**REQUEST**

The petition proposes to allow for the redevelopment and expansion of the existing Panthers’ Practice Facilities and associated accessory uses.

Staff recommends approval of this petition upon resolution of outstanding issues related to transportation, land use, site and building design, and environment.

SHEET NUMBER
RZ-2.0

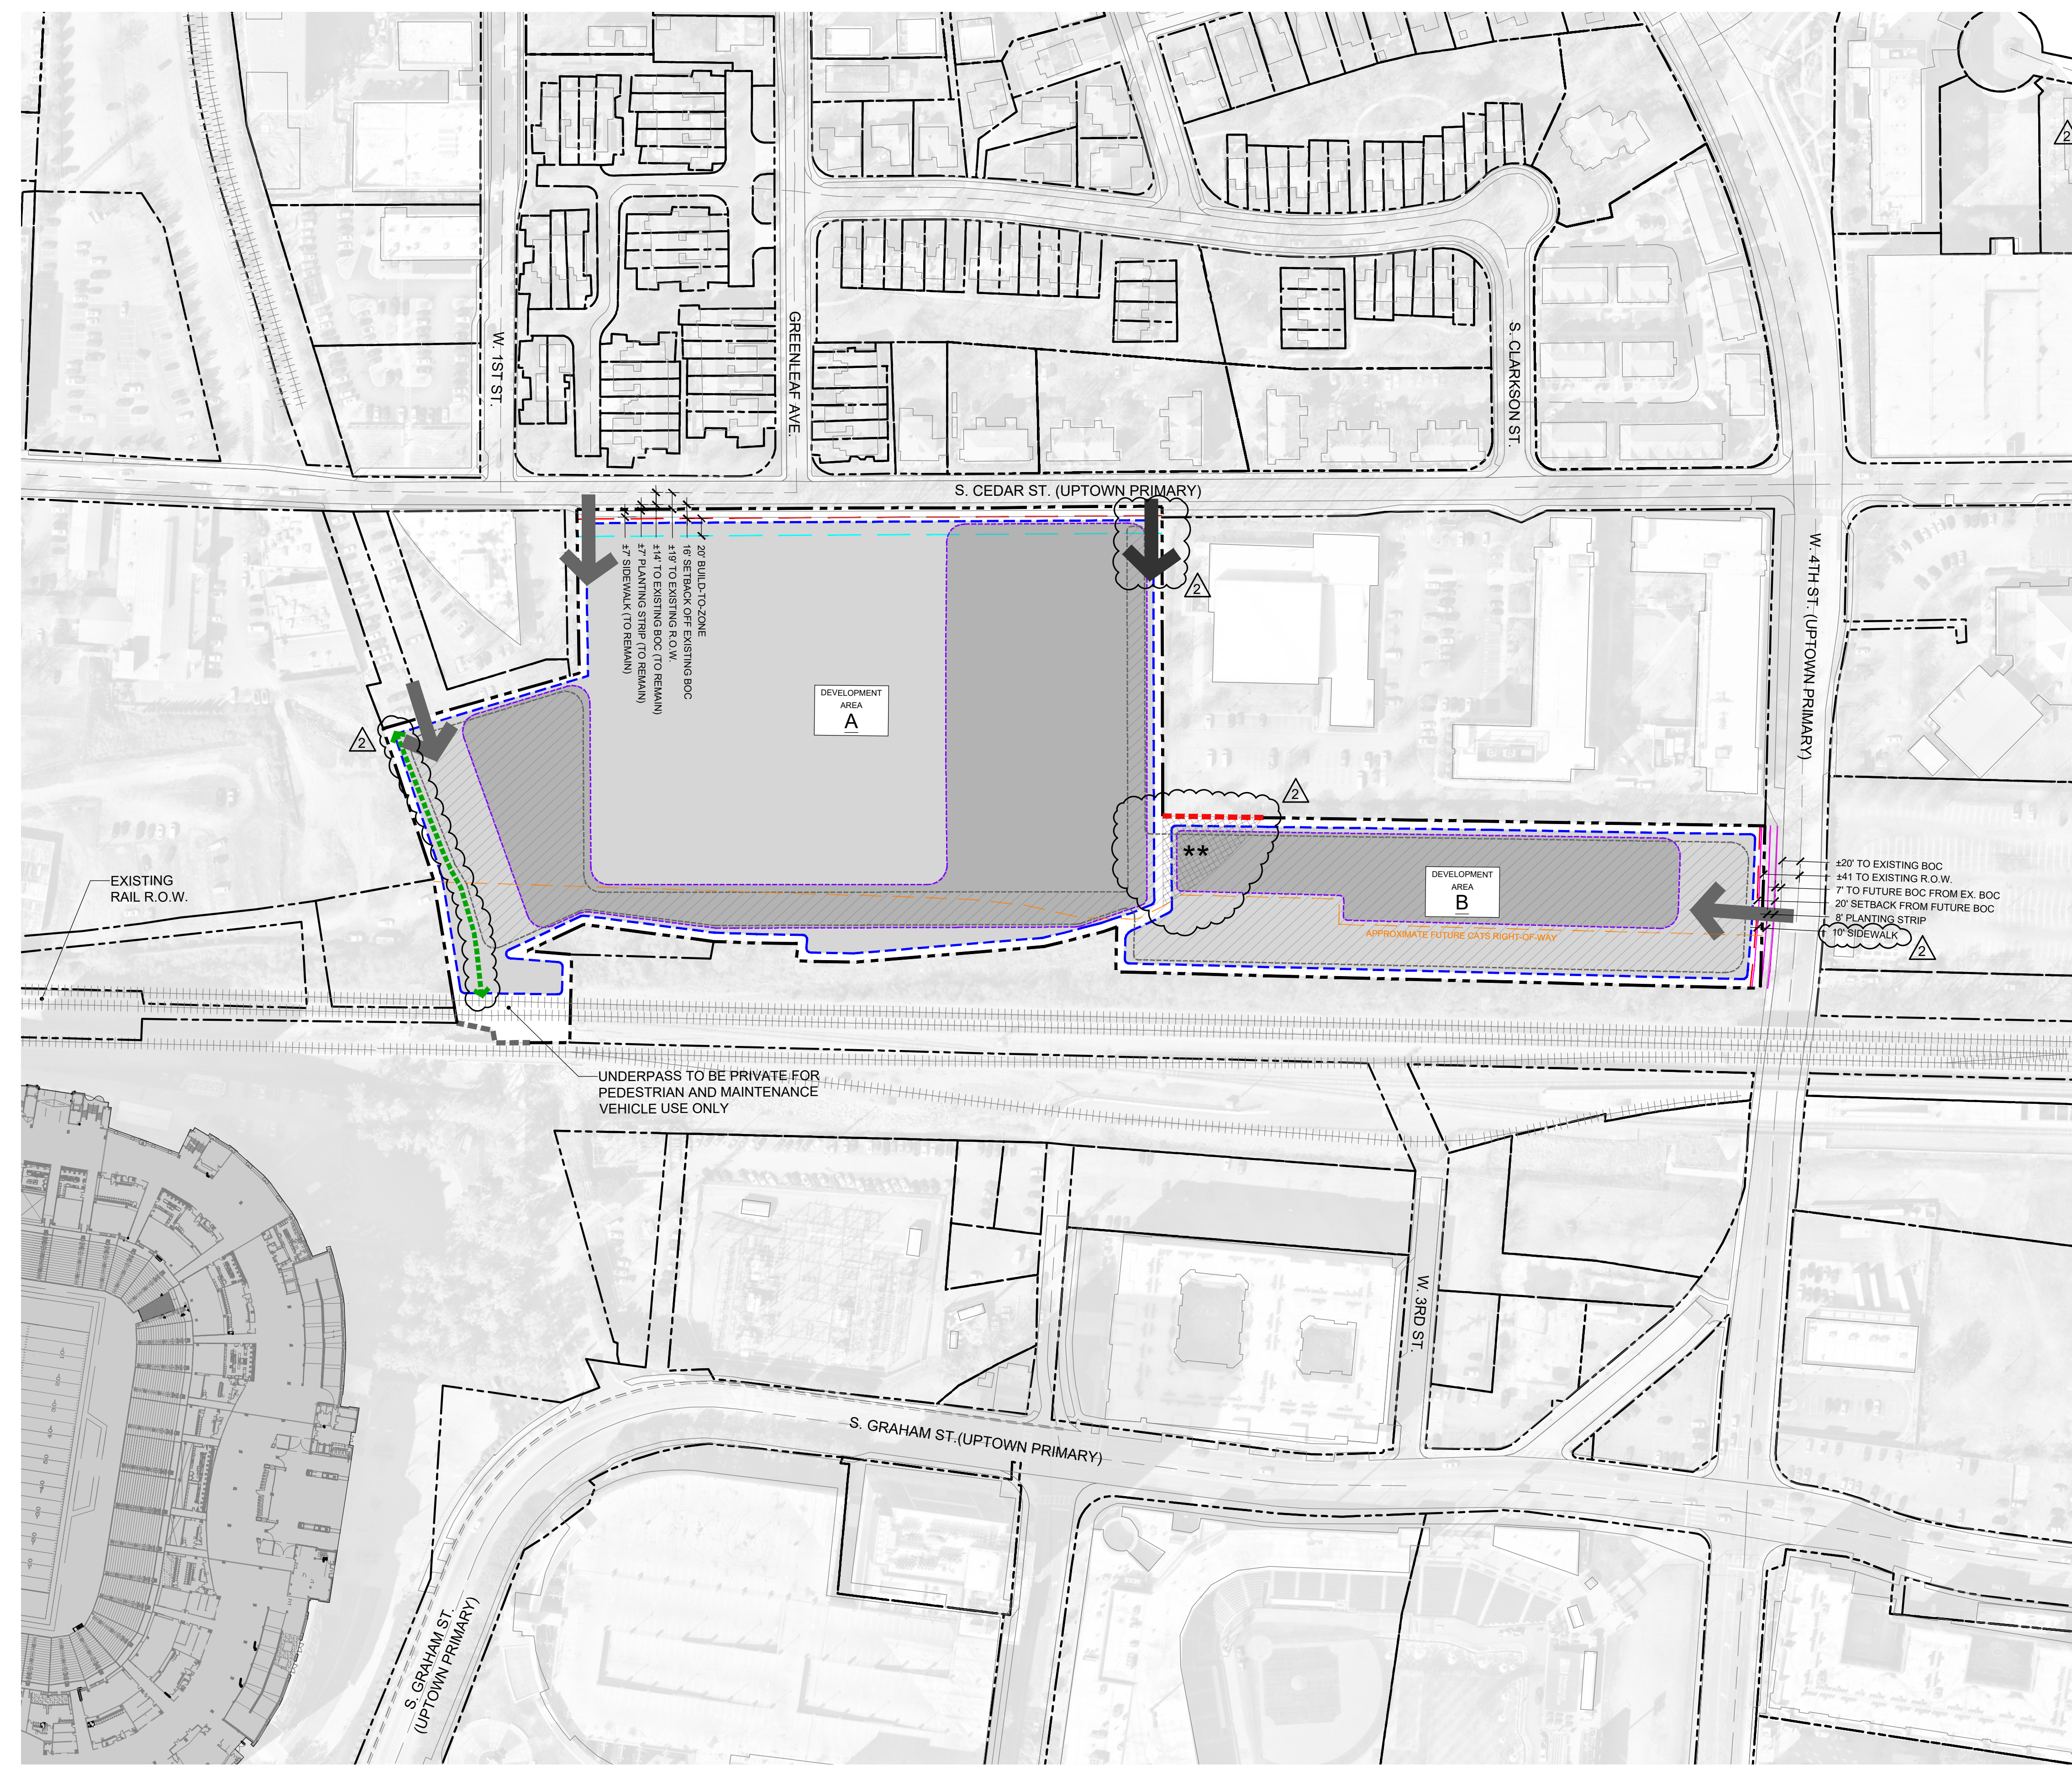
6. Add a proposed maximum building height for Development Area B.
7. Add details clarifying which proposed standards may be met on the stadium portion of the property in explicit and clear language.

14. Add typical cross sections for rideshare areas that would be expected along South Cedar Street and West Fourth Street.
15. Modify the EX provisions for Article 22 and section 4 of the conditional notes to remove all language except that which references a master signage package and the commitment to not orient signage towards the residential uses along Cedar Street.
